From: Megan Belanger
Sent: 24 January 2024 11:35
To: Chris Wentworth
Cc: Planning
Subject: Ecology Response - 23/03428/OUT

I've reviewed the ecological information submitted with this application. The surveys are up-to-date and provide a good overview of the ecology of the site. However, I have a few concerns about the lack of Skylark mitigation proposed. I also need to see the full BNG metric to ensure that it's accurate. I believe this outline application includes some vegetation removal and ground works – if this is the case, I'd like to see the CEMP up front, prior to a decision being made. I've explained this in further detail below. I also provided some comments on other conditions I'd recommend.

Relevant Output from the Biodiversity Metric 3.1 Calculation Tool

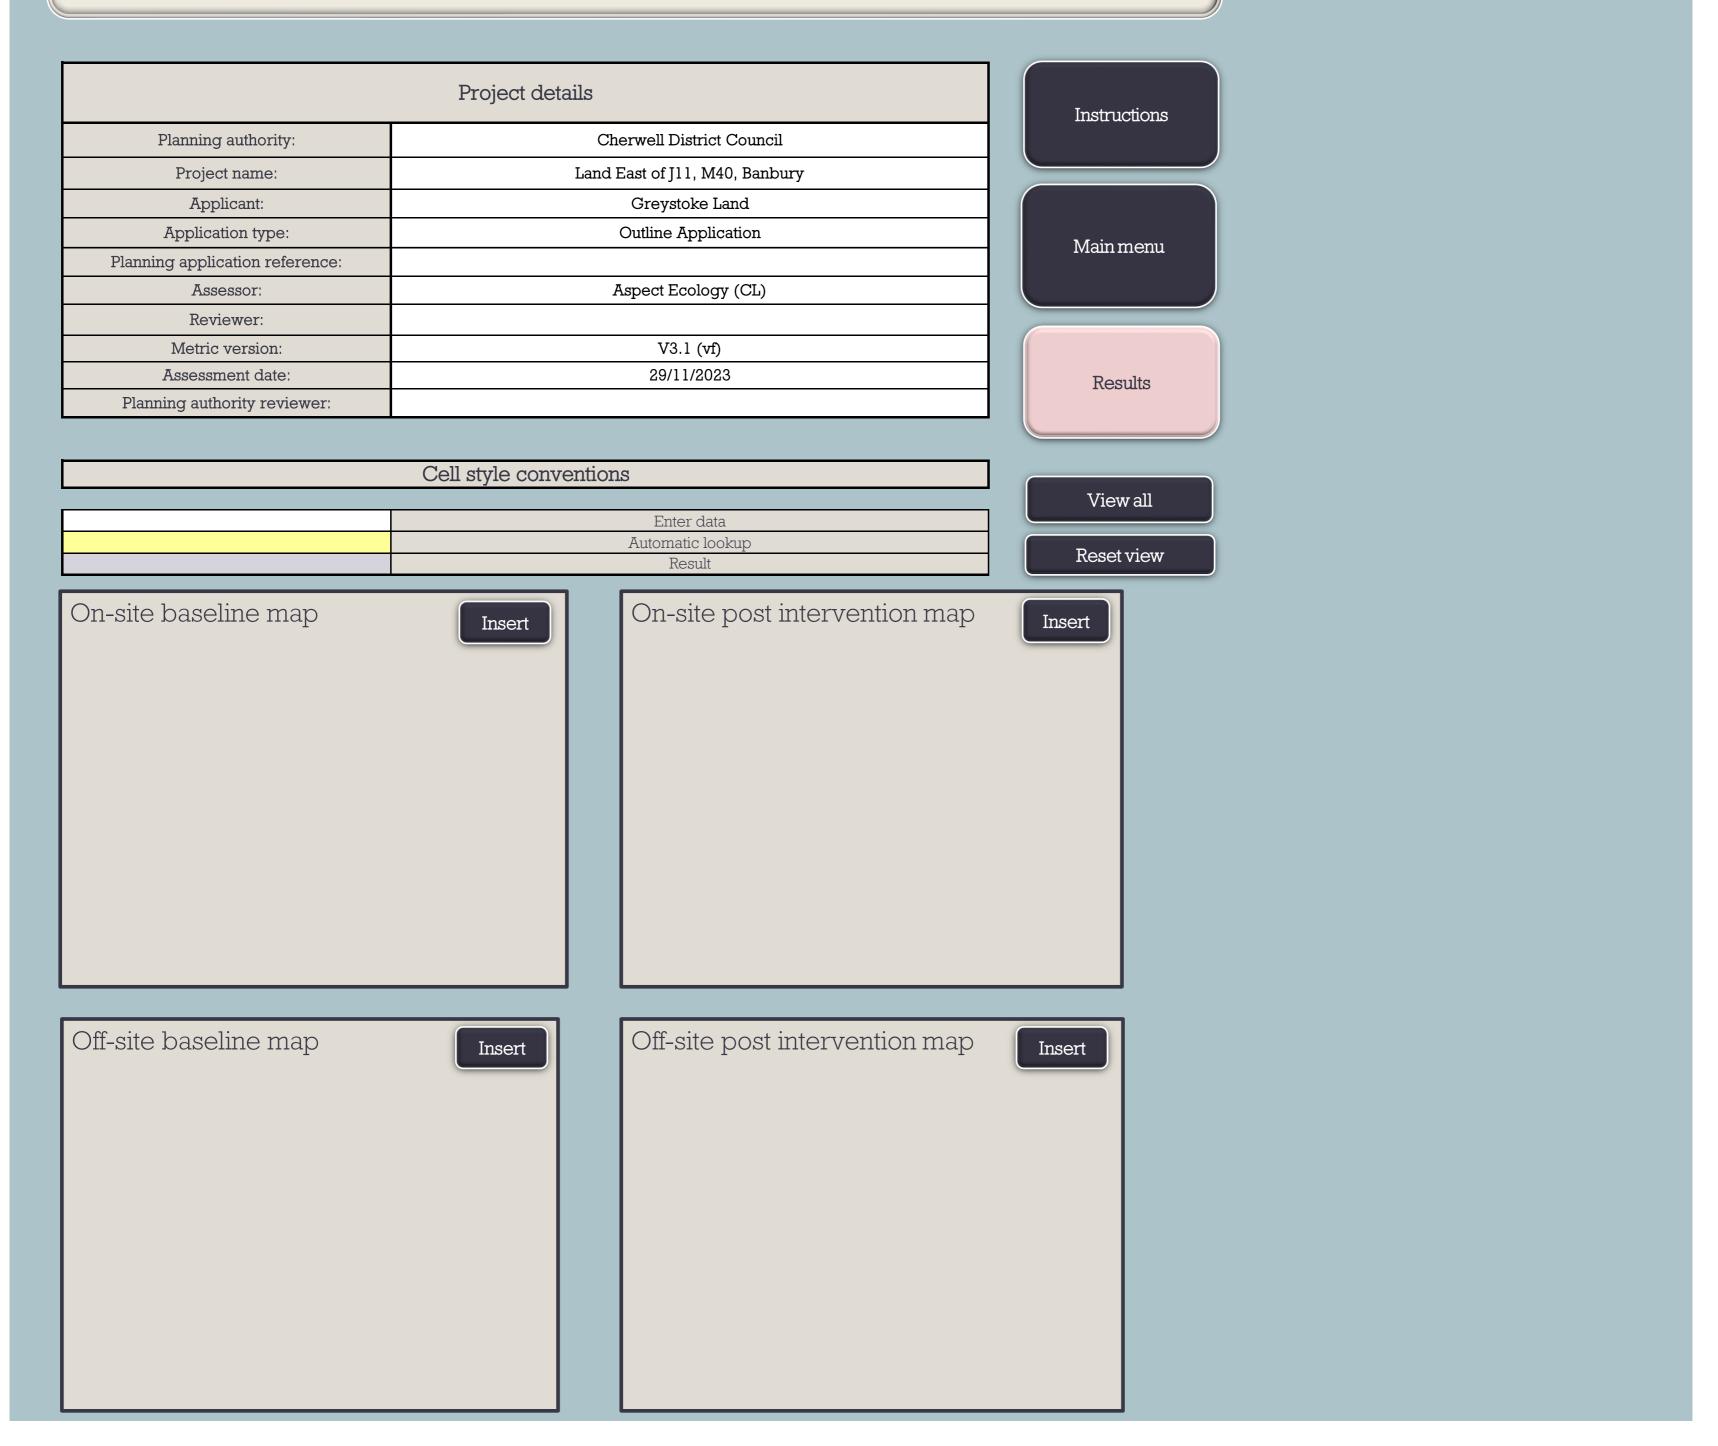
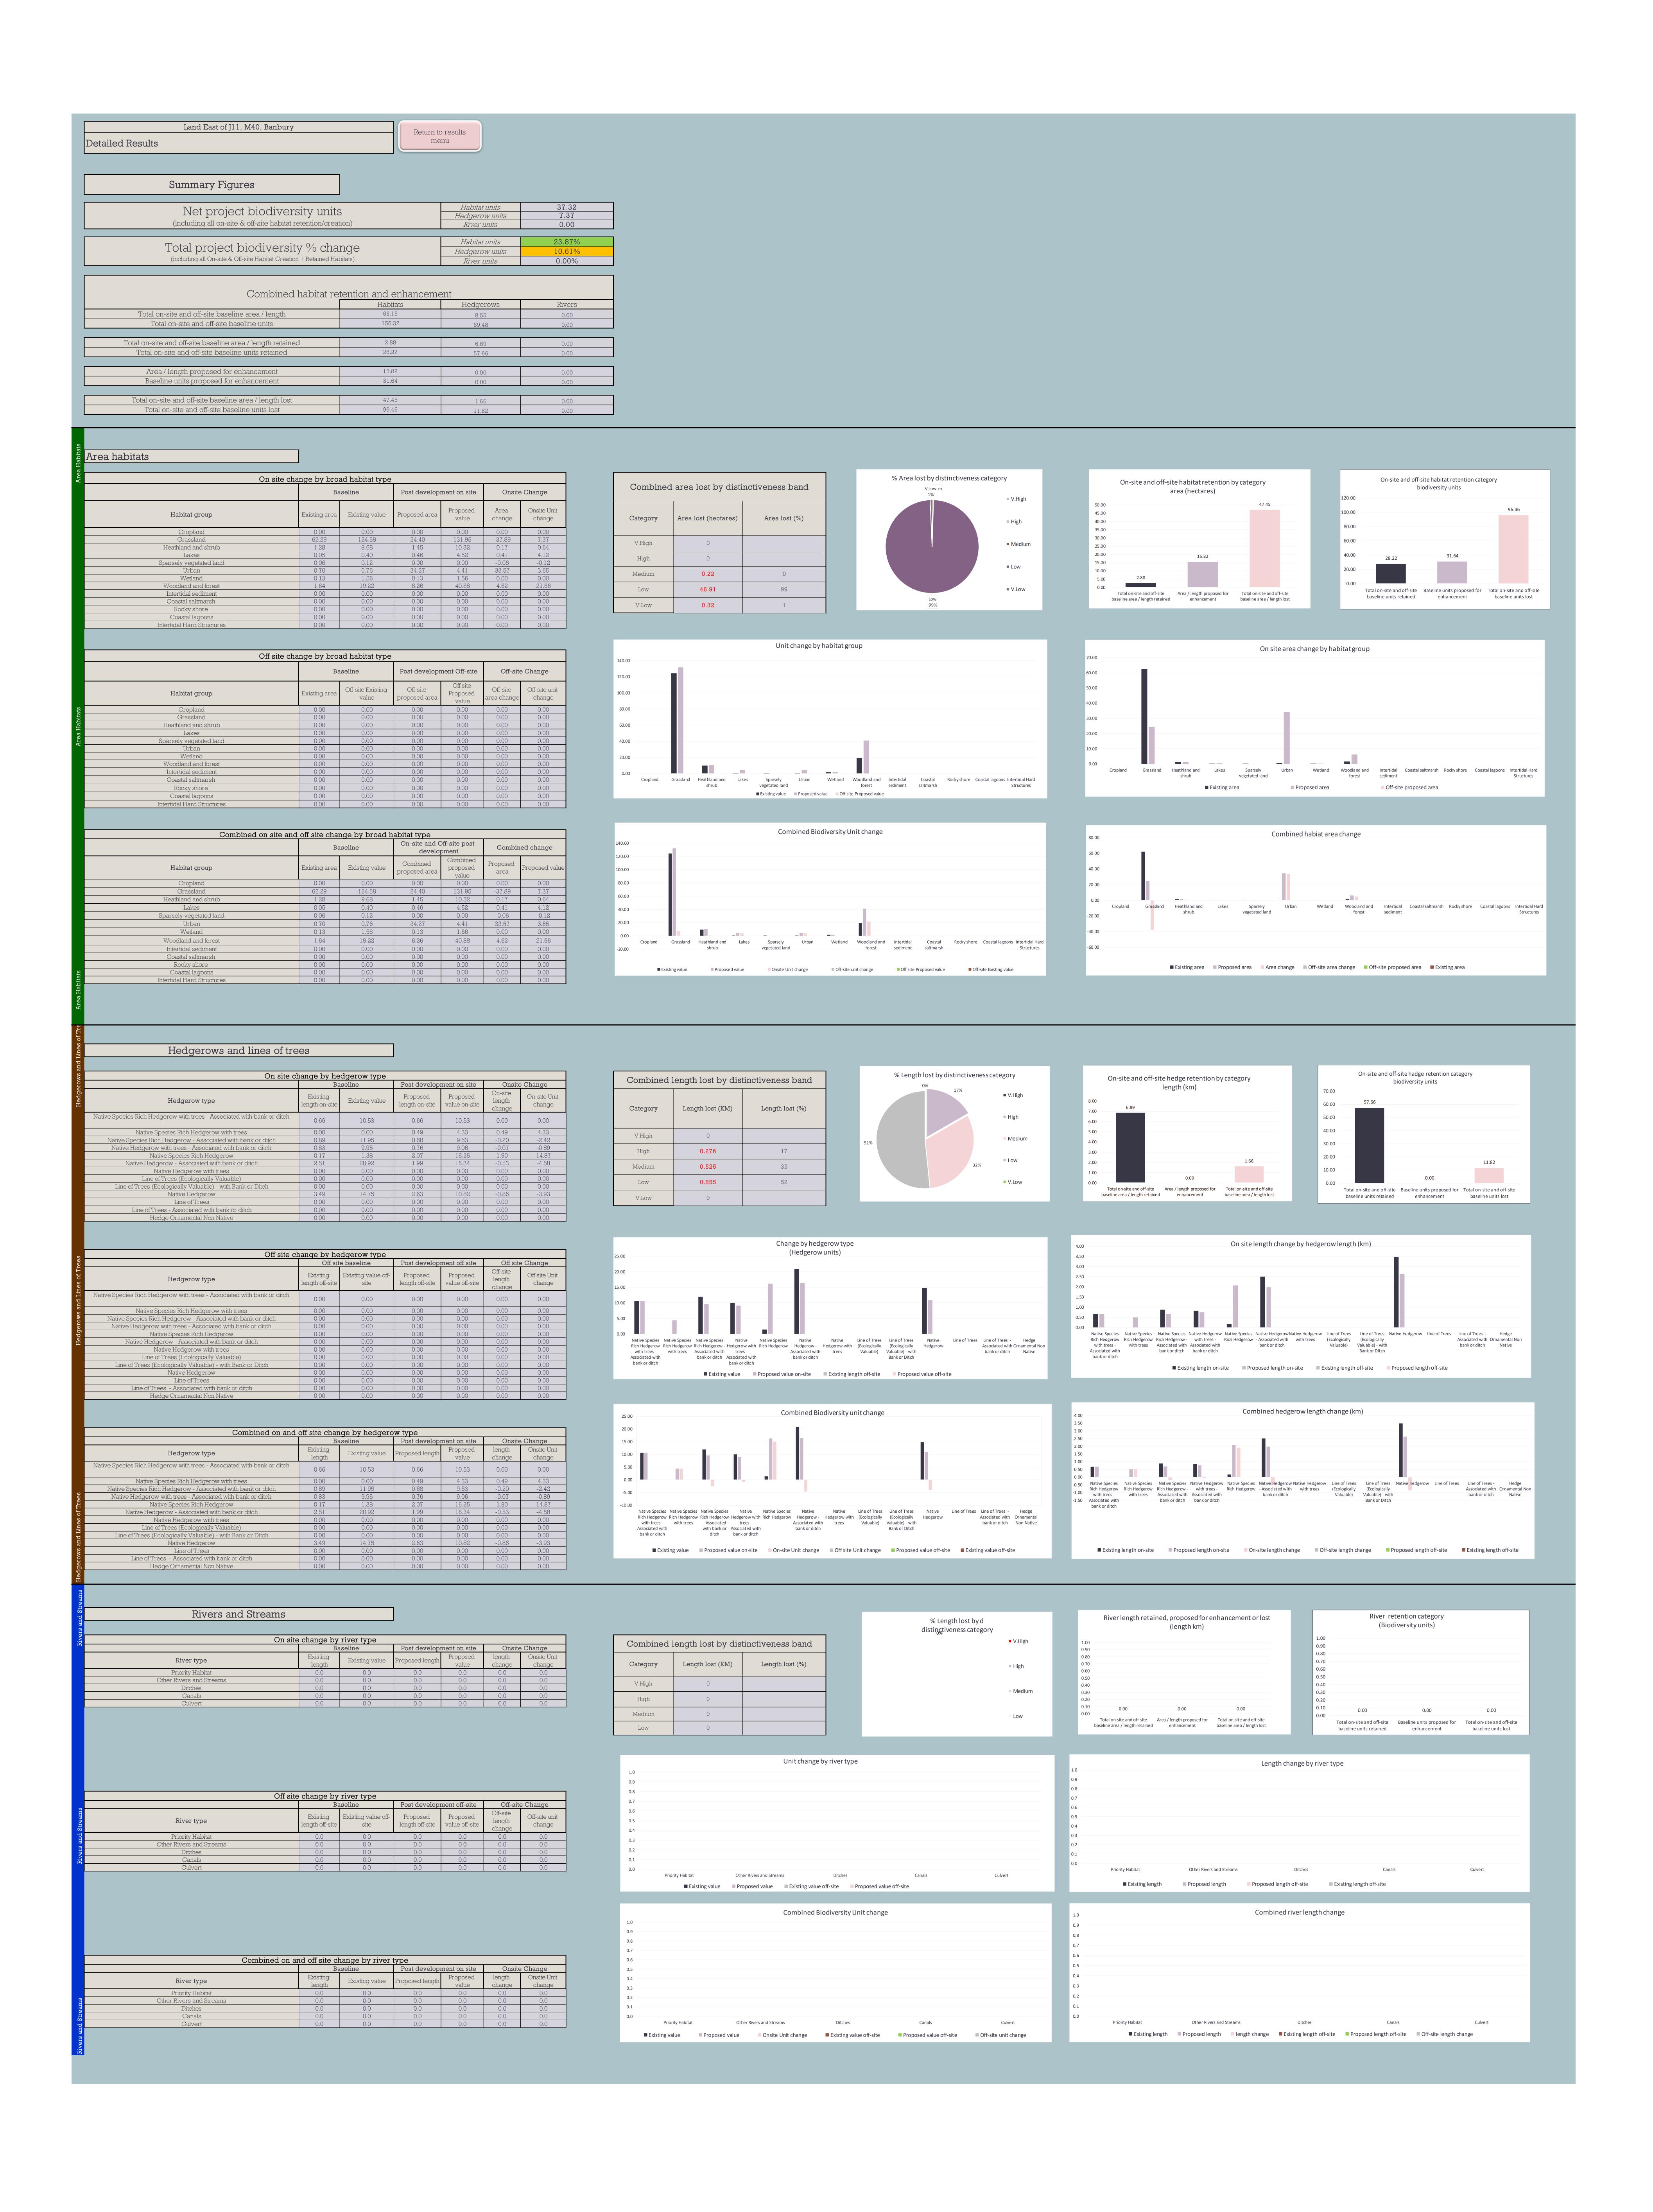
The Update Habitat and General Faunal Survey and Biodiversity Net Gain Assessment provided by Aspect Ecology in November 2023 includes details on how BNG (at least 10%) will be achieved on site. It also includes the details of specific species enhancements (section 5.2.2) which should be incorporated into the development. I cannot find the actual metric (excel format) for this site. I would need to review this to determine if the BNG figures are accurate – could this please be provided?
